Attn: Shivesh Singh, Department of Planning
23 Bridge St, Sydney 2000

RE: Scottish Hospital Proposal, Paddington NSW
Ref # MP09_0016

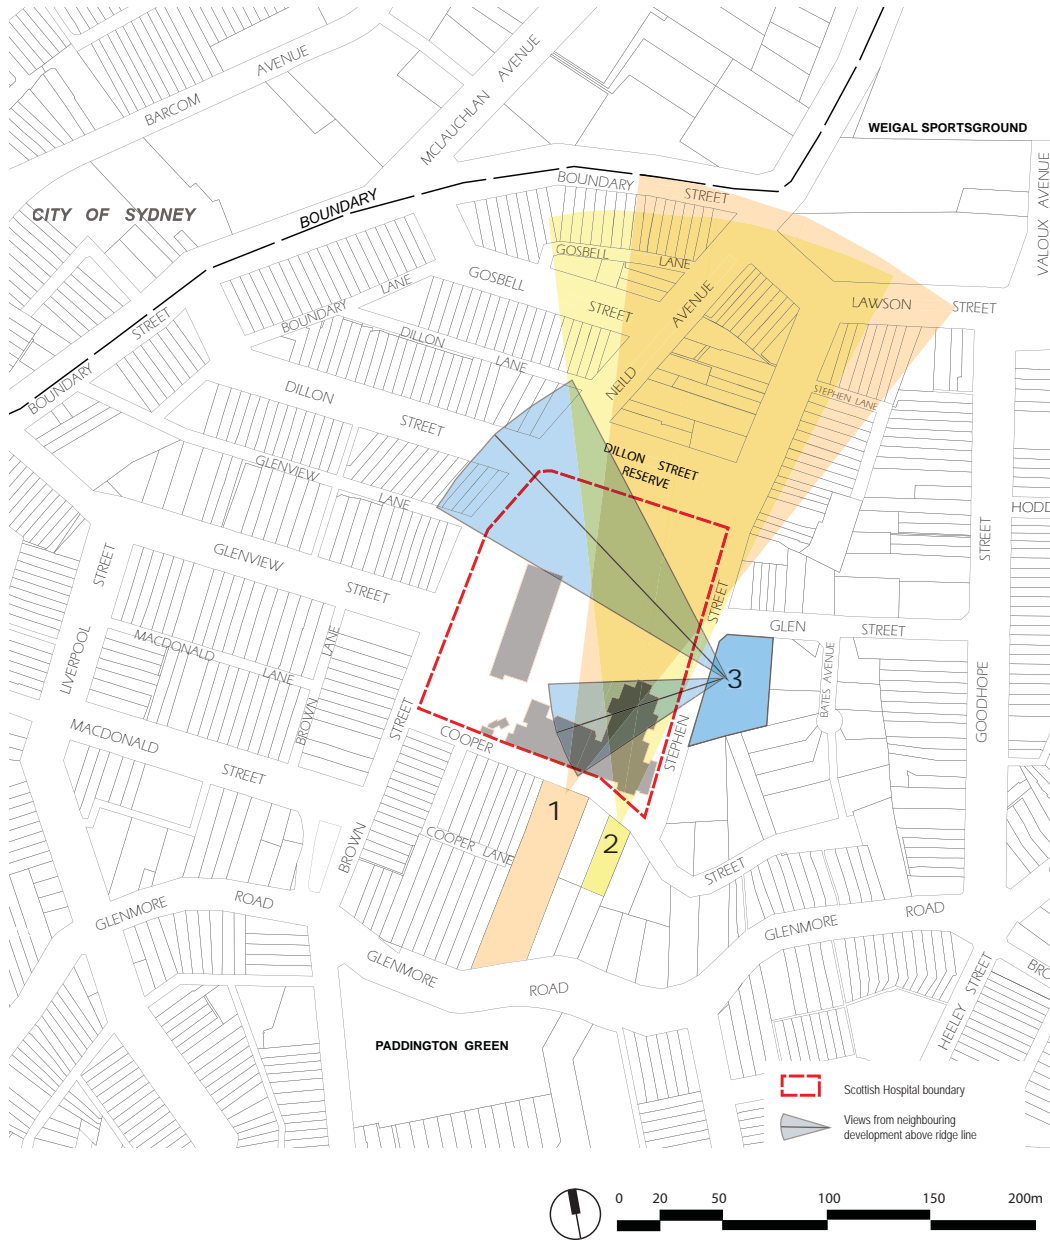
Page 19 of the Urbis EA Report states that "Green, heavily vegetated edges characterize the view looking down Stephen St", this apparently contradicts the above statement and also the Concept Masterplan that states the vegetation along Stephen St is of low retention value. The trees form a continuous 'green canopy' along the eastern boundary of the site that provides a very significant local landscape element.

STEPHEN STREET ELEVATION

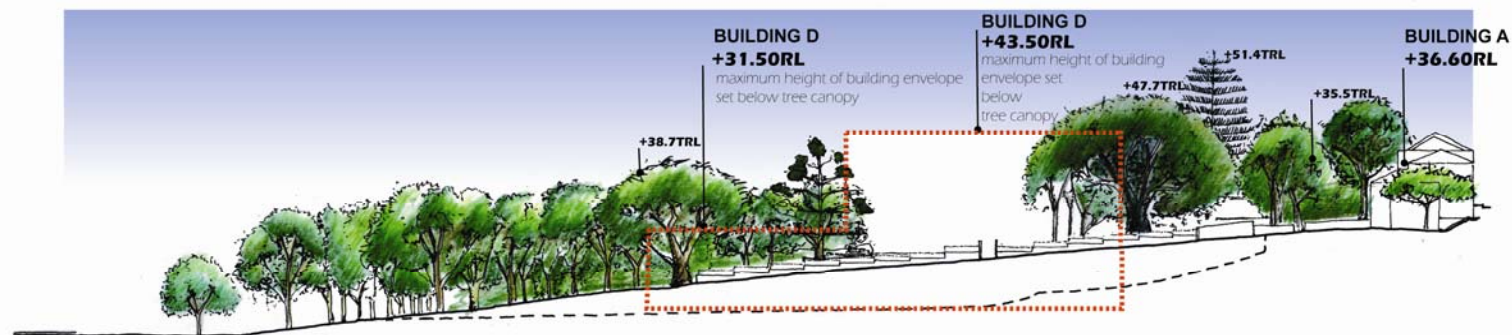
The proposed RCAF building will dominate and overshadow the 3 storey apartment building at 38 Stephen St and the 2 storey apartment building on the corner of Stephen and Glen Sts whilst creating a building gulley with the tower building at 40 Stephen St.

The boundary setback for the RACF varies from as little as 3.2 metres up to 6.2 metres. Vegetation will be further reduced when egress for fire stairs is included, and if footpath widening is approved subject to a Voluntary Planning Agreement (VPA) proposal with Woollahra Council.

- The RACF building is up to 6 storeys high (18.3 metres to roof parapet height) which is much higher than most other buildings in the local area. The local characteristic is a mix of terrace houses and two-storey walk-ups. Its height, bulk and usage are significantly different to the surrounding residential precinct.

Proposed Shadows - 21st June 12pm

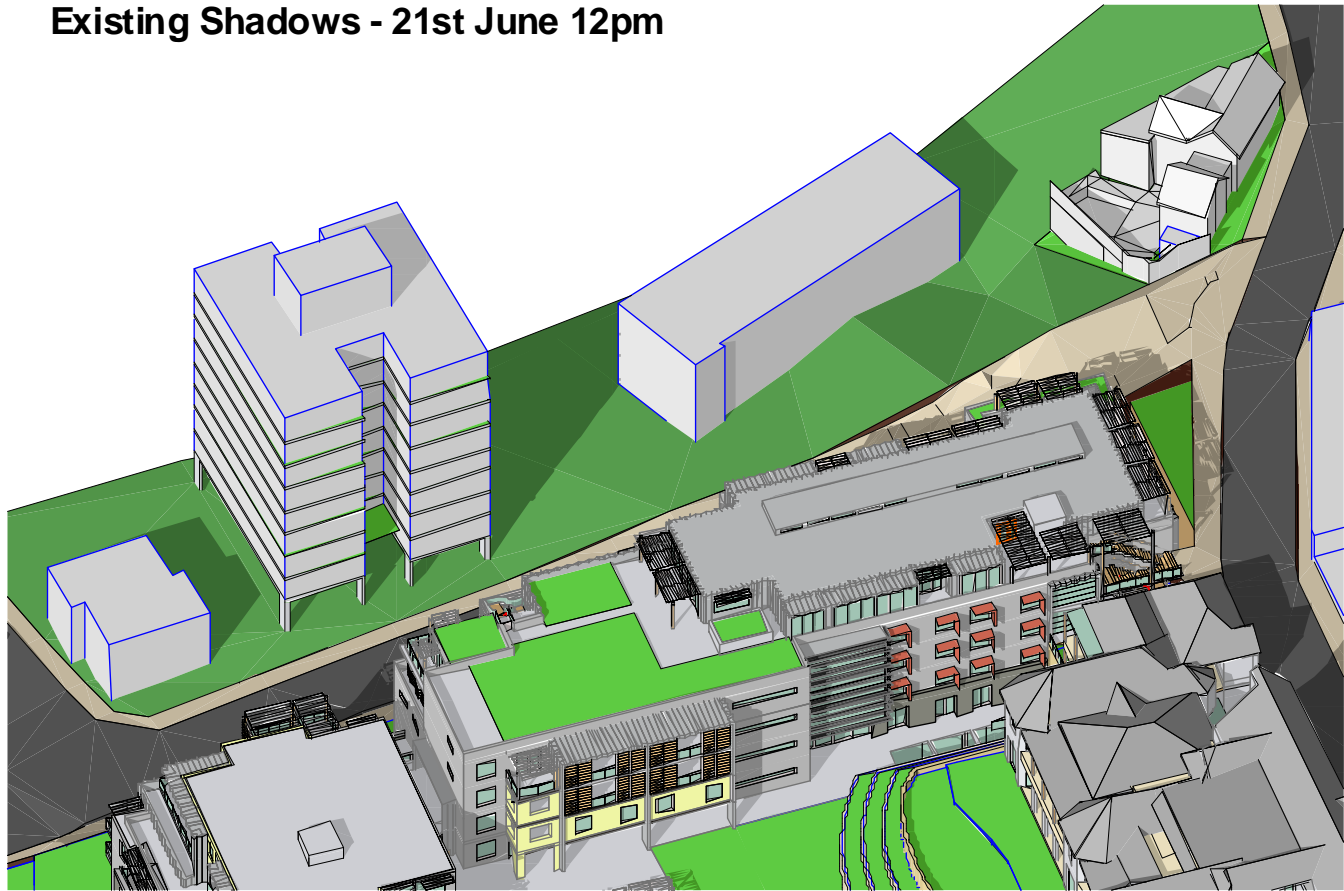
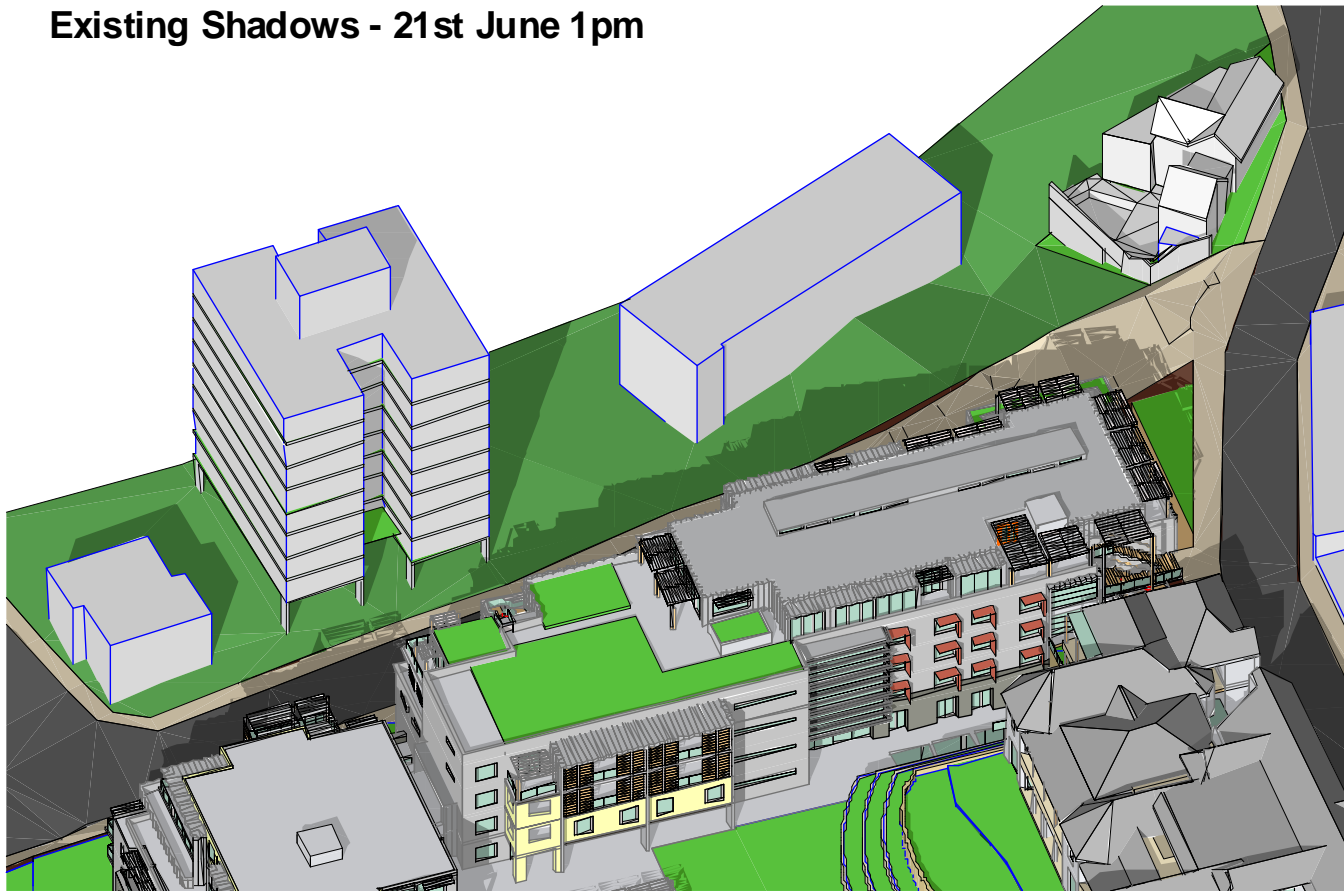
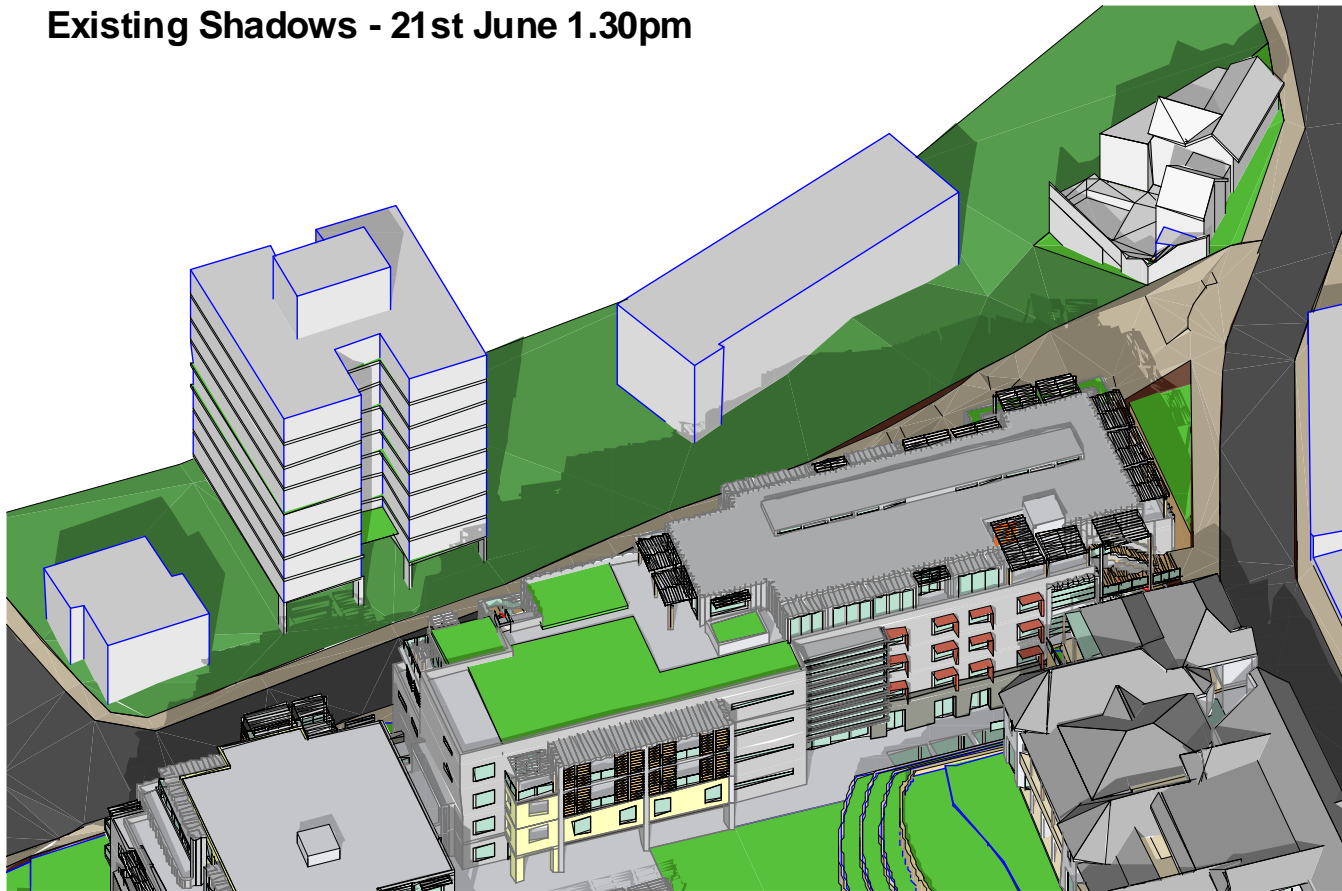
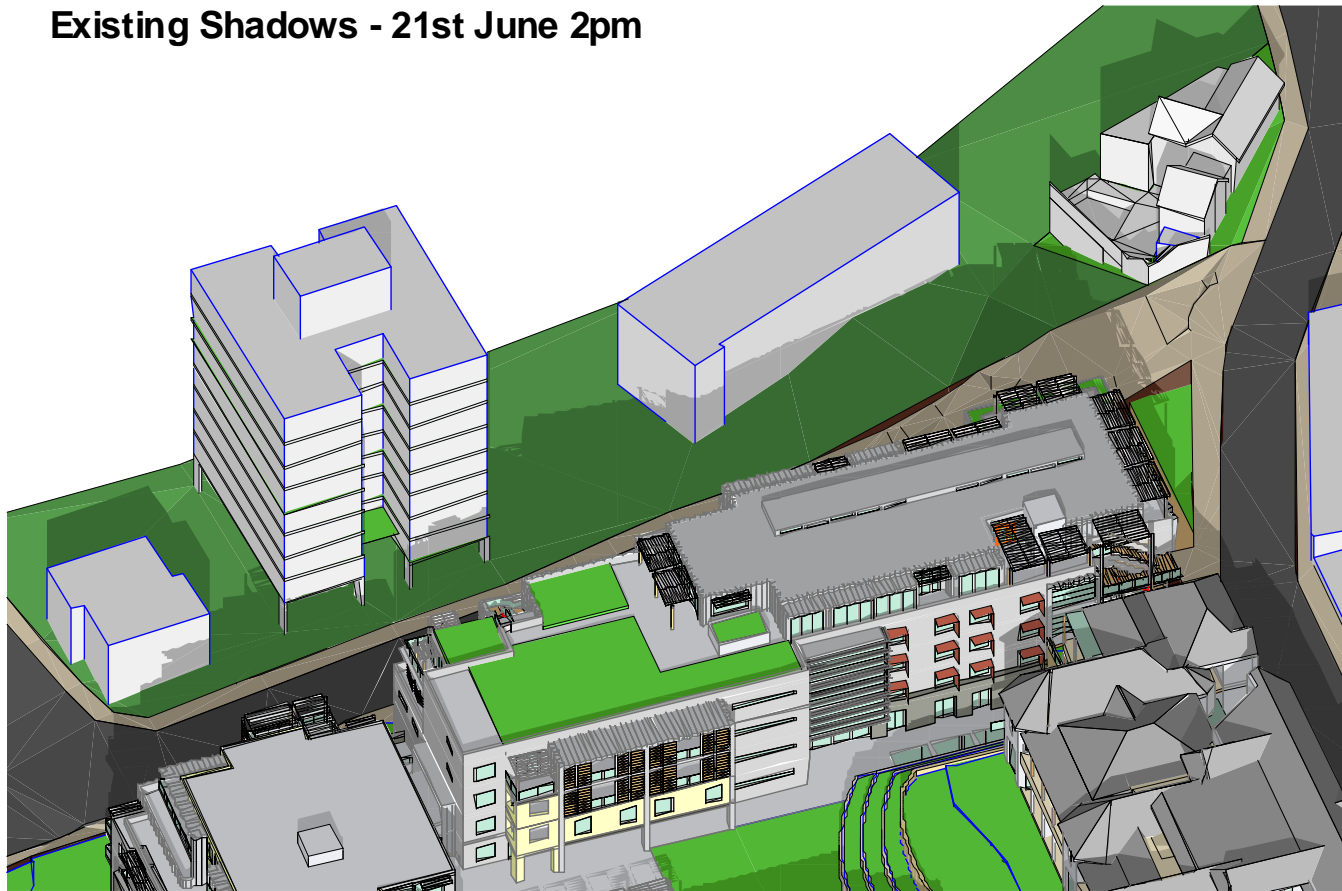
The proposed bulk RCAF and ILU buildings to Stephen St will begin to shade ground level apartments at 38 Stephen St by midday in mid winter and shade almost the entire building at 38 Stephen St by 2pm. Additionally the first floor apartments at 40 Stephen St are shaded by 12.30pm in midwinter increasing to nearly 50% of the building in shadow by 4pm. This is absolutely unacceptable; setbacks must be increased to allow adequate daylight to dwellings at 38 and 40 Stephen St that do not achieve any other solar access.
